An Coimisiún Pleanála appeal

Third-Party Planning Appeal

Planning Authority Reference: LRD26A/0051/WEB

Property principally affected: No. 26 St Vincent's Park, Blackrock

Figure 13.22 – The south and east elevations of the permitted Block D1 (ABP-303804-19)

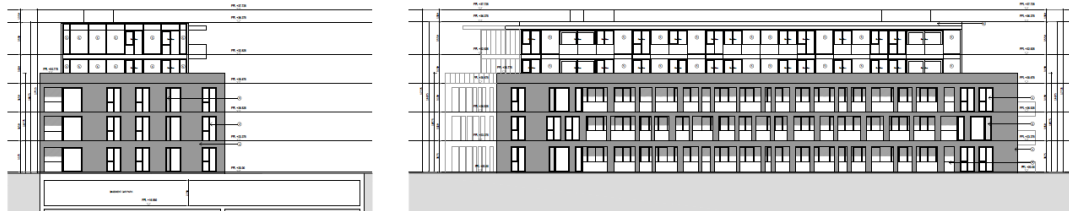
The previous permission for a five-storey D1 should not be treated as establishing that further height and massing at this location are automatically acceptable. There is an important distinction between accepting the **principle of a building** and accepting its subsequent **material enlargement.**

The 2019 Dún Laoghaire-Rathdown County Council Chief Executive's Report for ABP-303804-19 described the then Block D1 as stepping from five storeys down to three storeys on its south-eastern

That earlier stepped form is significant because it demonstrates that the transition in building height towards the existing low-rise residential area was expressly recognised in the design and planning assessment of this particular interface.

The **2019 Chief Executive's Report** recorded D1 stepping down to three storeys towards St Vincent's Park.

Figure 13.29 – Proposed south east elevation of Block D1

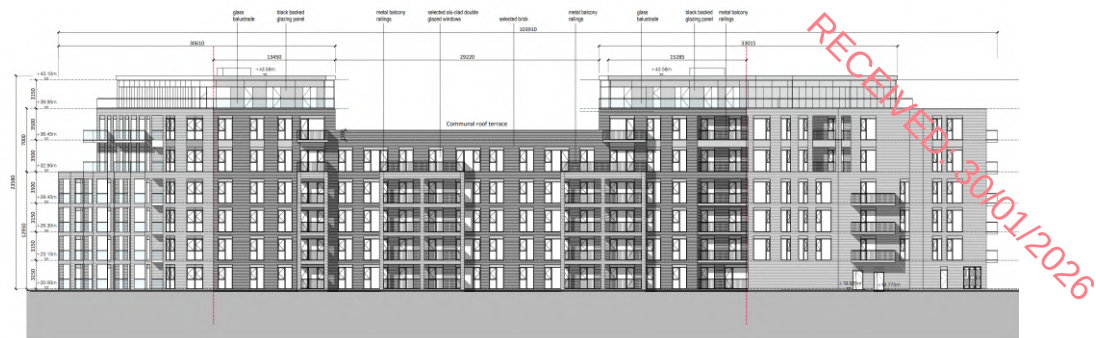
D1 changes from the previously permitted five-storey, 50-apartment building to a building reaching **seven storeys and containing 125 apartments**.

A development may be capable of accommodating substantial height internally while still requiring a **clear step down at its boundary with established low-rise housing**.

By virtue of its single-storey form, the property is particularly susceptible to the effects of substantially taller neighbouring development. Unlike a multi-storey dwelling, it has no upper residential floor capable of obtaining outlook, daylight or sunlight above surrounding built form.

The cumulative B4/D1 relationship therefore raises particular concerns regarding:

- visual dominance and an increased sense of enclosure;
- loss of outlook and reduction in visible sky;
- overlooking and perceived loss of privacy from elevated residential accommodation;
- additional overshadowing and reduction in sunlight/daylight;
- artificial lighting from upper-floor windows, balconies and communal areas; and
- increased residential activity associated with the substantial enlargement of D1.

Figure 4.5- Site section through D1 and St. Vincent's Park

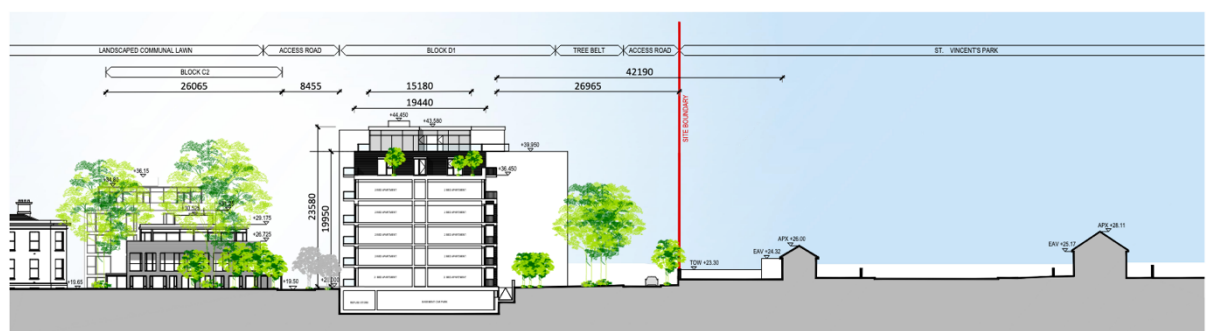
The present D1 instead rises to **seven storeys**.

Contextual intensification. I do not object in principle to appropriate residential intensification of the St Teresa's lands. However, intensification must respond to its receiving context. The transition from the established low-rise houses of St Vincent's Park to the substantially taller and bulkier D1/B4 built form at this sensitive edge is not, in my submission, a graduated or contextual transition. It represents a sharp increase in vertical scale adjoining an established residential environment.

EIAR Chapter 4 – Consideration of Alternatives explains the evolution of the design in the context of the potential to intensify development and make better use of the extensive development site. It also relies in part upon mature tree belts providing “partial screening” from adjoining residential properties (EIAR Chapter 4 – Consideration of Alternatives, PDF p. 8).

However, the desire to intensify a large development site does not mean that every part of that site is equally capable of accommodating additional height.

There is a fundamental distinction between **appropriate intensification** and **excessive intensification at a sensitive residential boundary**.

The relevant question is not simply whether the St Teresa's site as a whole is capable of accommodating greater density and height. It is whether that additional height has been **appropriately distributed within the site**, having regard to the characteristics and sensitivities of its different boundaries.
